Proposed State Significant Development (SSD-10446) - Luddenham Resource Recovery Centre

We are writing in response to the public exhibition of the Environmental Impact Statement (EIS) for a Resource Recovery Centre (Proposed Development) at 275 Adams Road, Luddenham (Site). The Proposed Development is a State Significant Development under the *Environmental Planning and Assessment Act 1979*.

APPENDIX C -PRELIMINARY CONCEPT
ELIZABETH DRIVE/ADAMS ROAD INTERSECTION

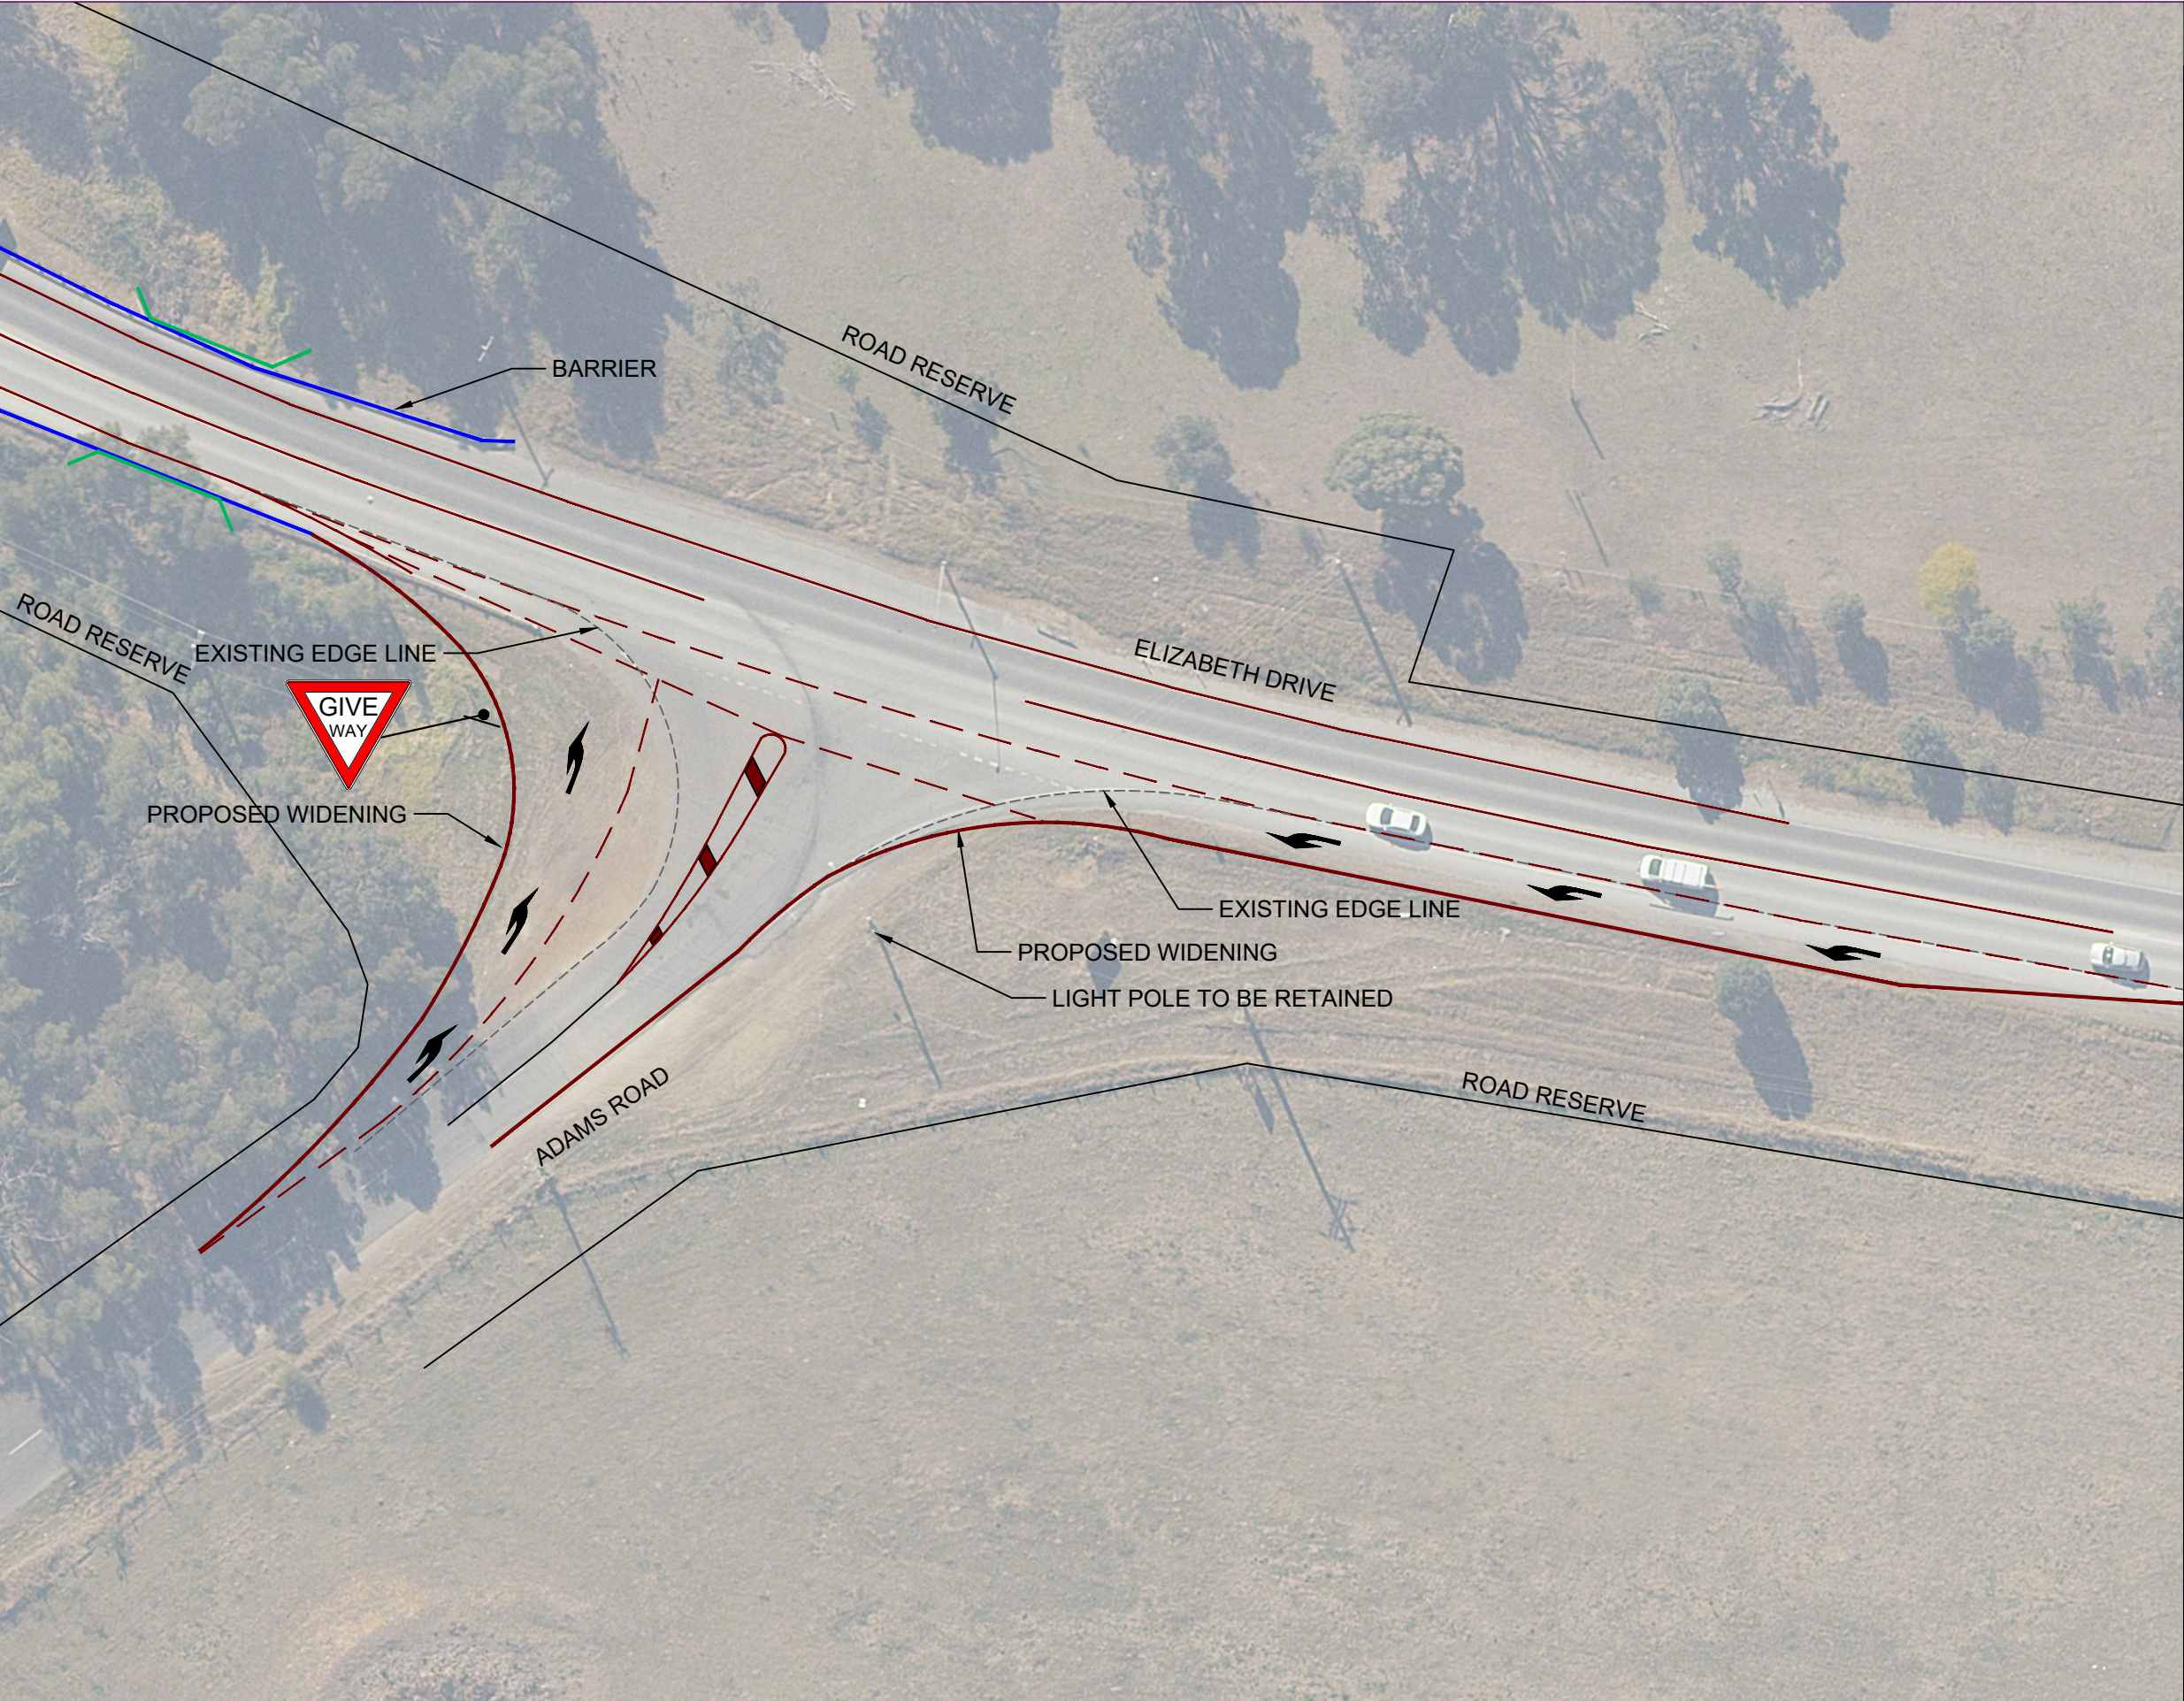
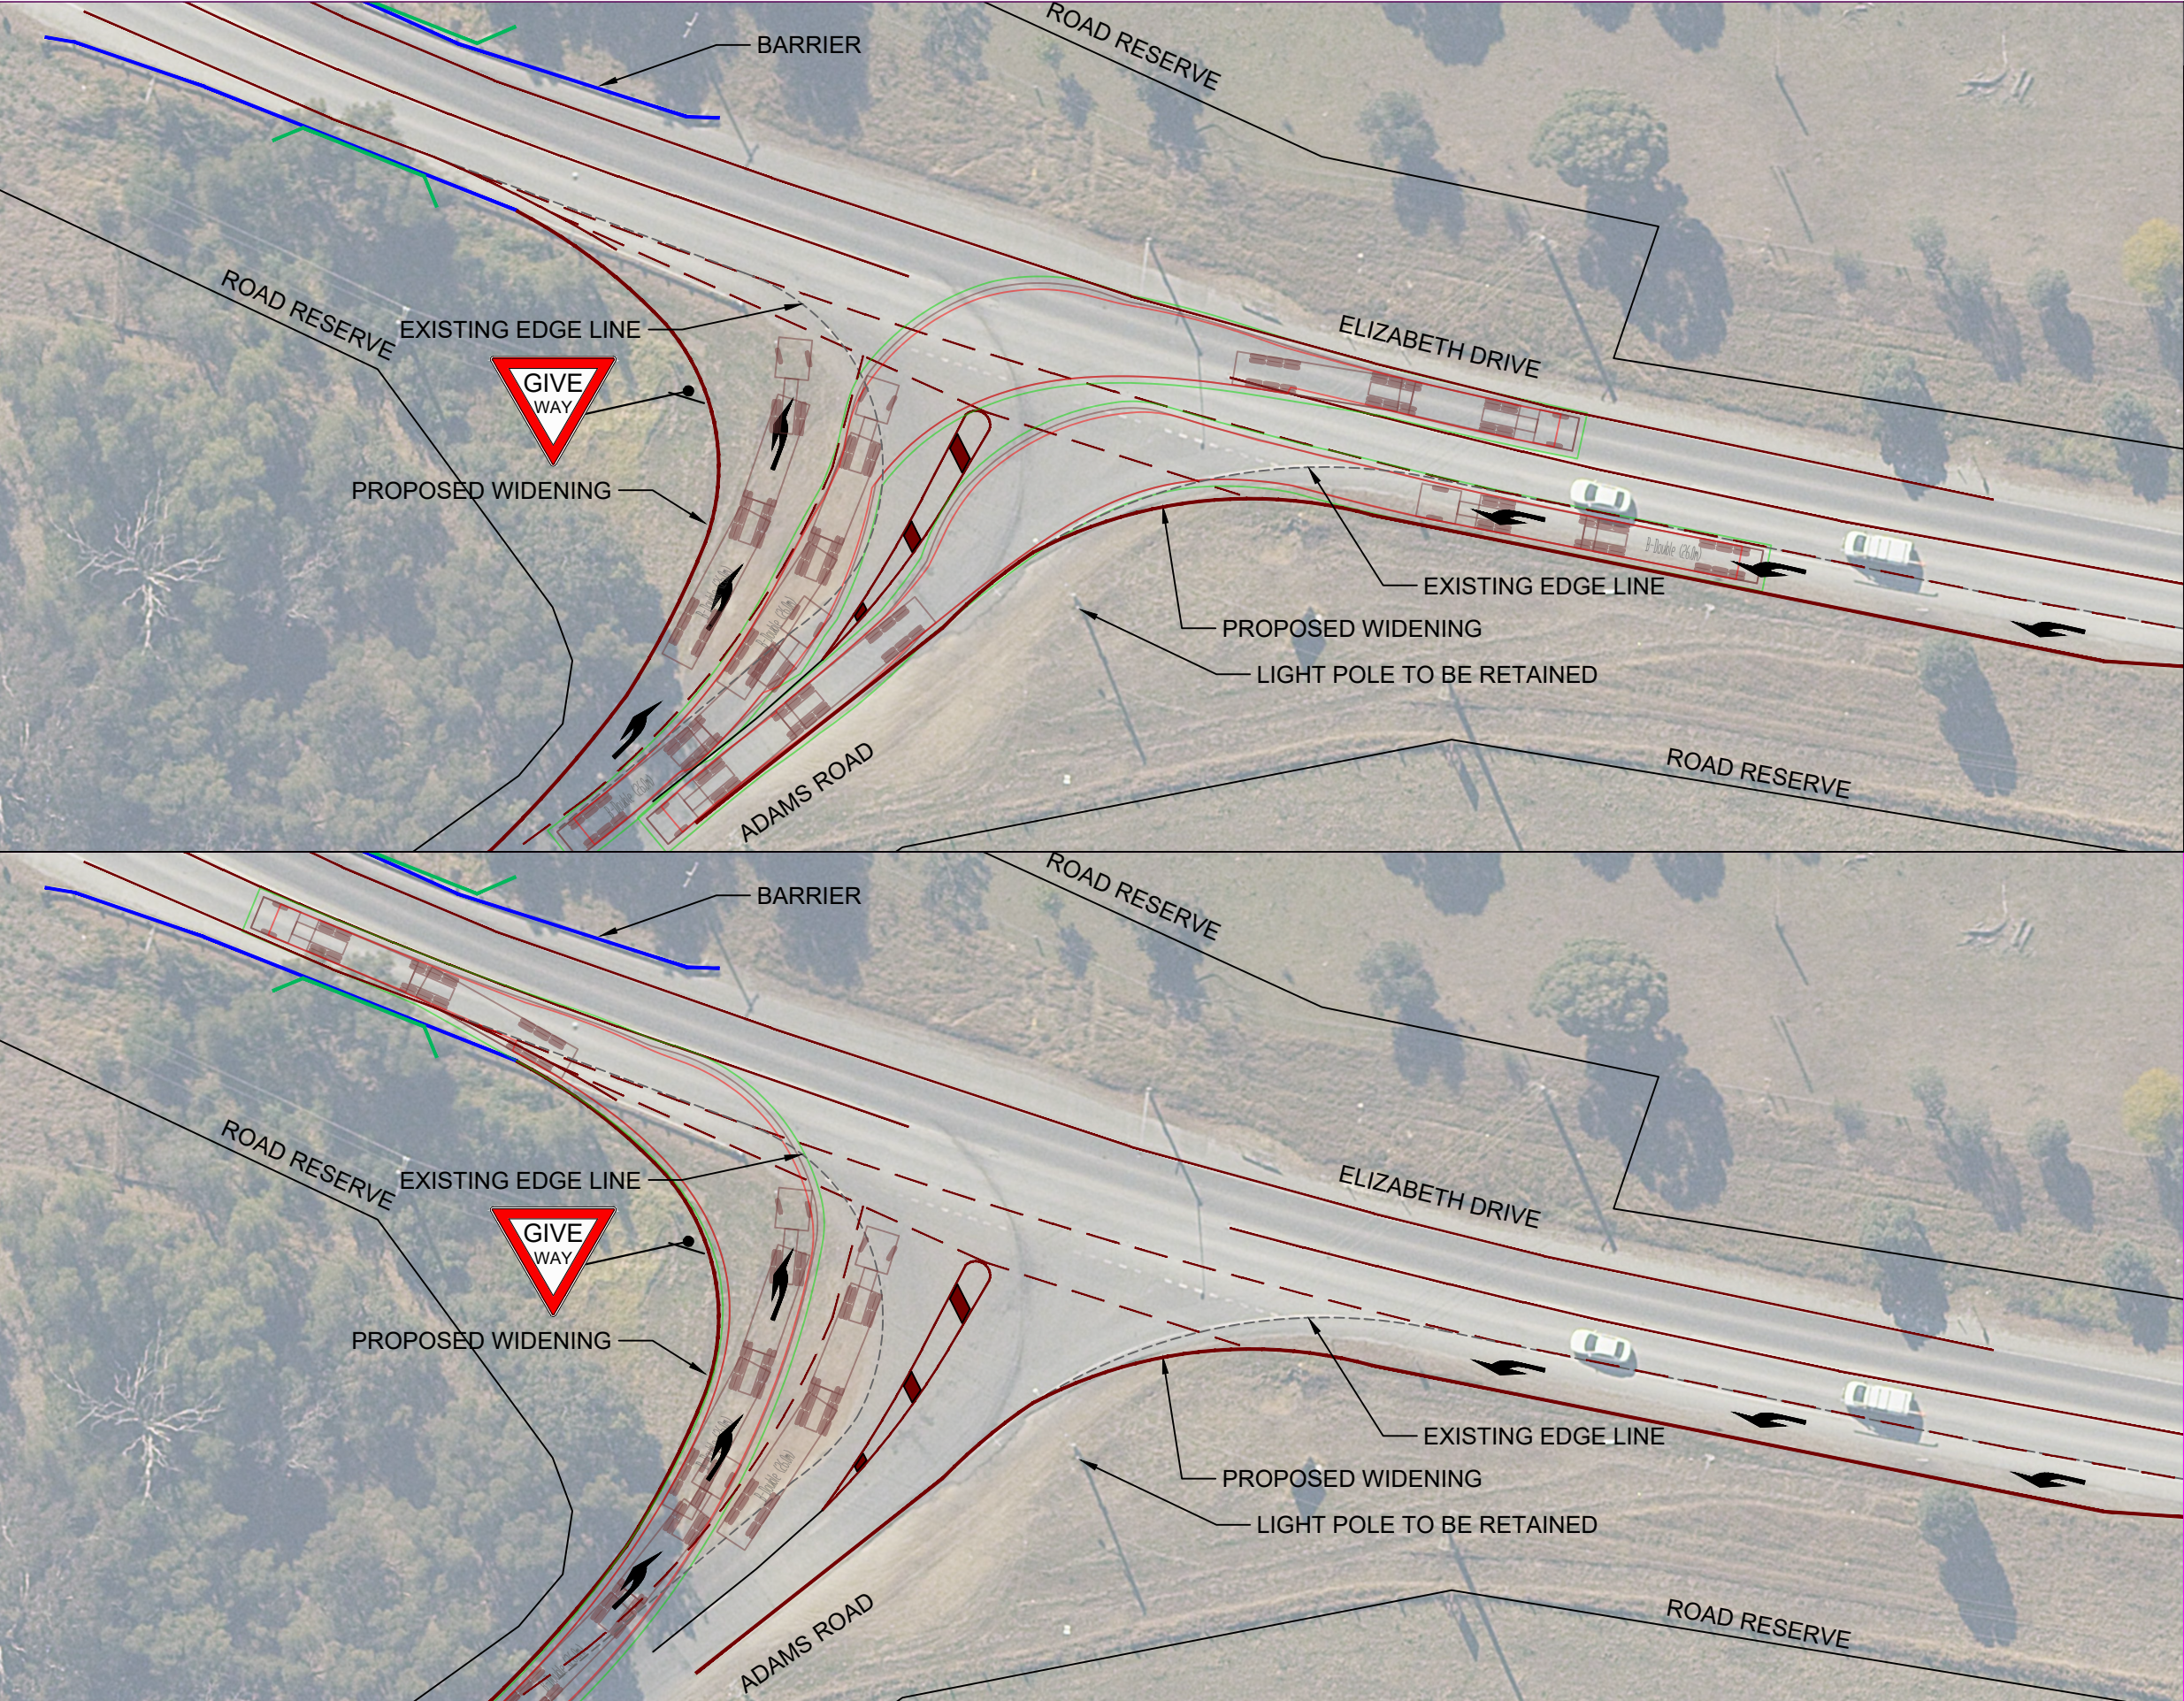
14. Therefore, the EIS should assess the impacts of the Proposed Development based on the current design and capacity of Elizabeth Drive, including the suitability of the proposed use occurring before any upgrade to Elizabeth Drive. In particular, the intersection of Adam Road and Elizabeth Drive may need to be upgraded as a result of the Proposed Development to ensure the safe operation of this intersection.
15. The traffic assessment, particularly the traffic volumes do not appear to have taken into account future development envisaged by the WSAP and therefore the impact to network capacities and intersection performances may not have been properly assessed. In addition, it is unclear if the assessment has taken into account construction traffic associated with the major infrastructure projects occurring in the vicinity of the site such as the Airport, M12 and Metro Rail.
